**KIRKLEES METROPOLITAN COUNCIL
INVESTMENT & REGENERATION SERVICE**

DELEGATED DECISION TO DETERMINE APPLICATIONS FOR LISTED BUILDING CONSENT

Reference No:	2023/65/91676/W
Site Address:	90, New North Road, Edgerton, Huddersfield, HD1 5NE
Description:	Listed Building Consent for change of use of offices to bed and breakfast, installation of lightwells and new window opening to sides(within a Conservation area)
Recommending Officer:	Lucy Taylor

DECISION – Grant Listed Building Consent

PROPOSED EACH SHOWER
INTERNAL PODS AND W/C

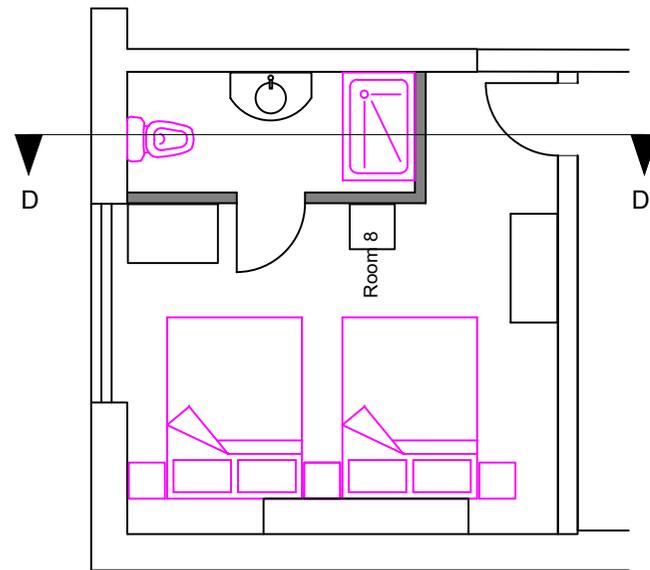
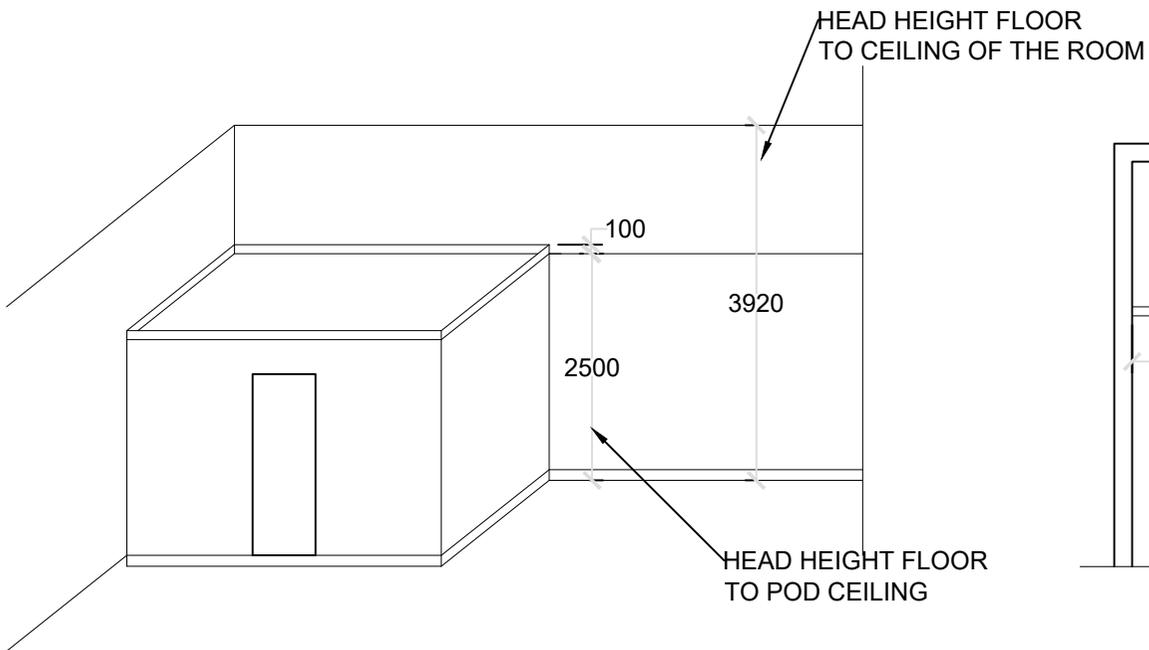
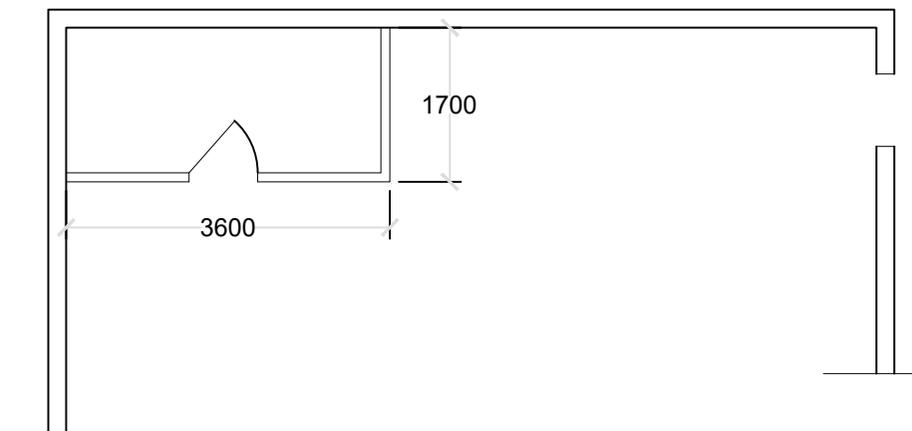
Indicative drawings of the bathroom pods in rooms 6, 8, 9, 10, 11, 12 and 13 have been submitted and show that skirtings and picture rails are retained and boxed in, and the proposed floor plans show that new soil vent pipes will be connected into existing drainage.

With regard to the en-suites, in rooms with surviving architectural details, these interventions will lead to less than substantial harm to the significance of the Listed Building. However, the original plan forms can still be understood, and the harm has been mitigated against by the proposed pods being set below the decorative cornices within the rooms and fixed around the skirtings to ensure that these historic details are retained. The pods could be removed in the future if they are no longer required. It is considered that the public benefits of providing a viable use for the building outweighs this slight harm. Upon any grant of Listed Building Consent, a condition will be applied requiring architectural details to be retained and protected from damage as part of the installation.

TITLE CHANGE OF USE FROM OFFICES TO BED AND BREAKFAST
PROPOSED FIRST & SECOND FLOOR PLANS

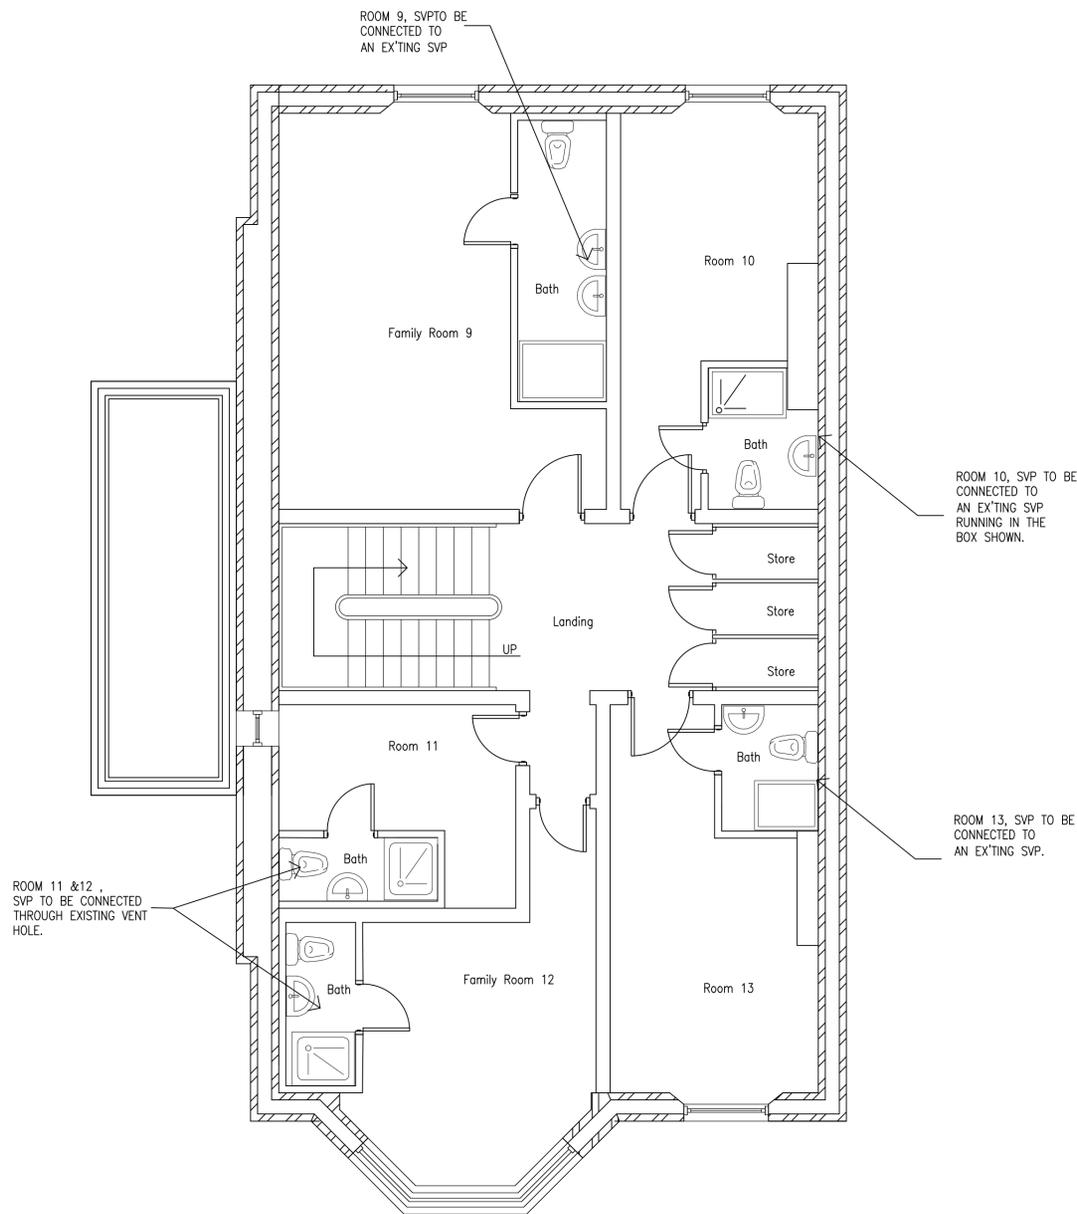
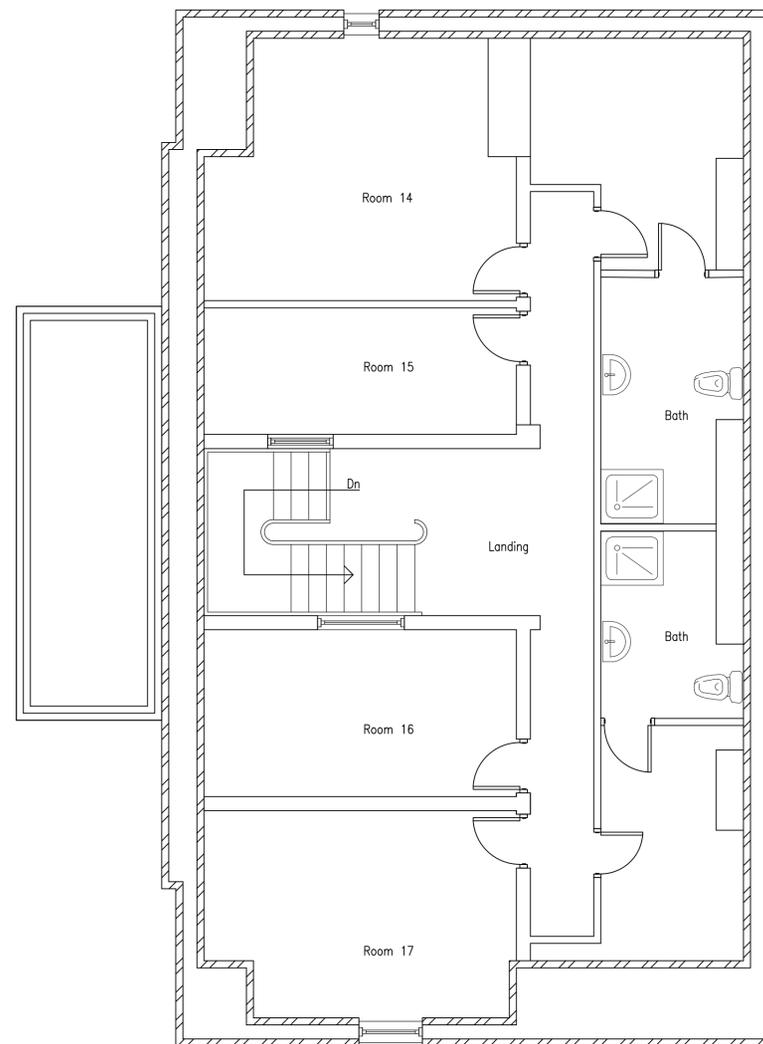
The introduction of a small first-floor window to room 11 to the right of the stair window is simple in design and timber framed, with the ashlar stone surround matching the ground floor window opening below. The minor harm to significance is outweighed by providing natural light and ventilation into the existing room.

TITLE CHANGE OF USE FROM OFFICES TO BED AND BREAKFAST  
PROPOSED BASEMENT & GROUND FLOOR PLANS

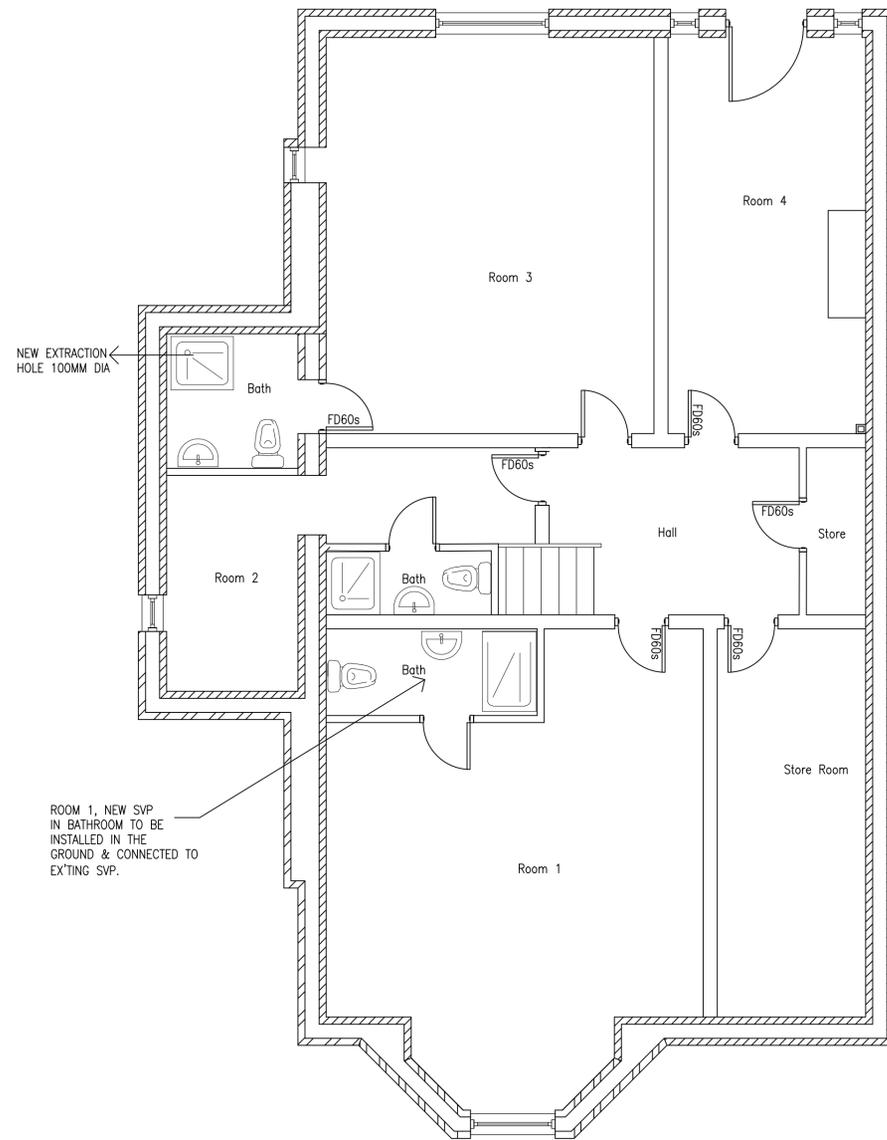
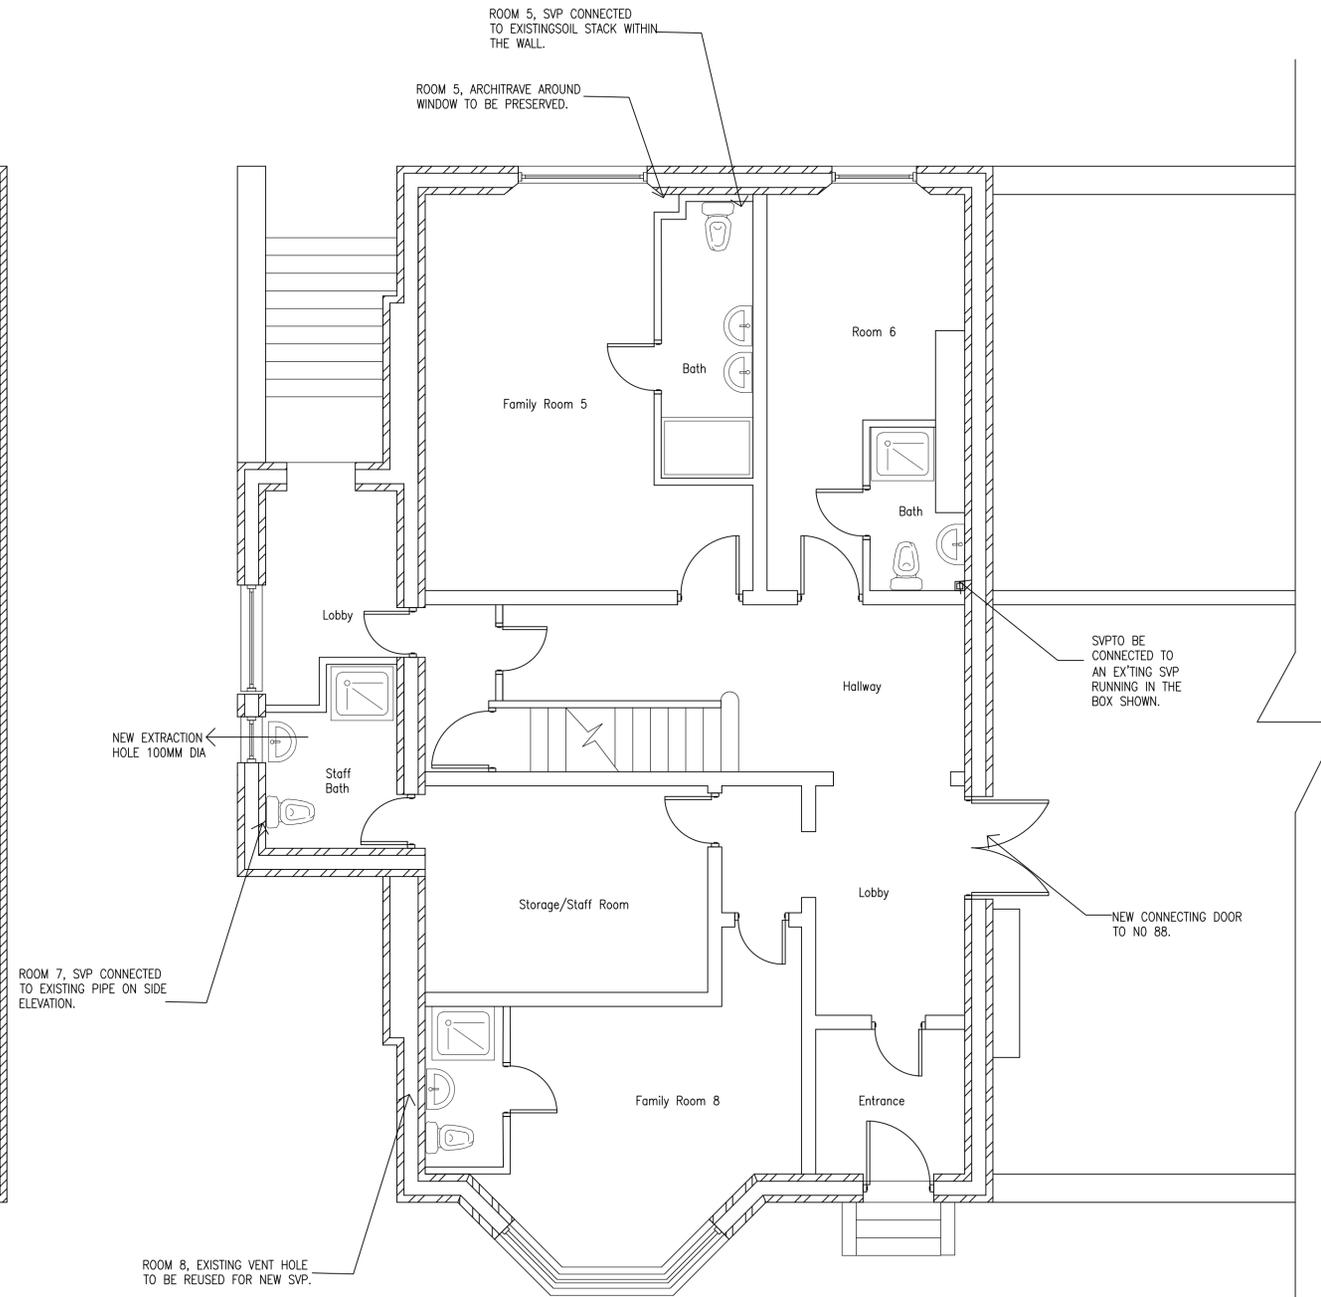
The proposed lightwells around the building are not visible from outside the site and have a negligible impact on significance. Their introduction will reduce dampness within the proposed habitable rooms within the basement by taking back the ground level. The retaining walls have been topped with natural stone copings which complement the character of the listed building. Timber windows are retained at basement level, also maintaining the character. Cement strap pointing and render has been applied to the external elevations at basement level and this must be carefully removed and replaced with flush pointed lime mortar, as such, a condition will be imposed upon any grant of Listed Building Consent.

4. Cement strap pointing and render applied to the external elevations at basement level shall be carefully removed and replaced with flush pointing in lime mortar with a mix of 1.5 parts Nosterfield sand, 1.5 parts Leyton Buzzard sand and 1 part NHL 3.5 lime mortar, unless an alternative mortar mix is agreed in writing by the Local Planning Authority, before the bed and breakfast accommodation is first brought into use. No power tools shall be used to remove the existing mortar and the mortar shall be flush pointed.
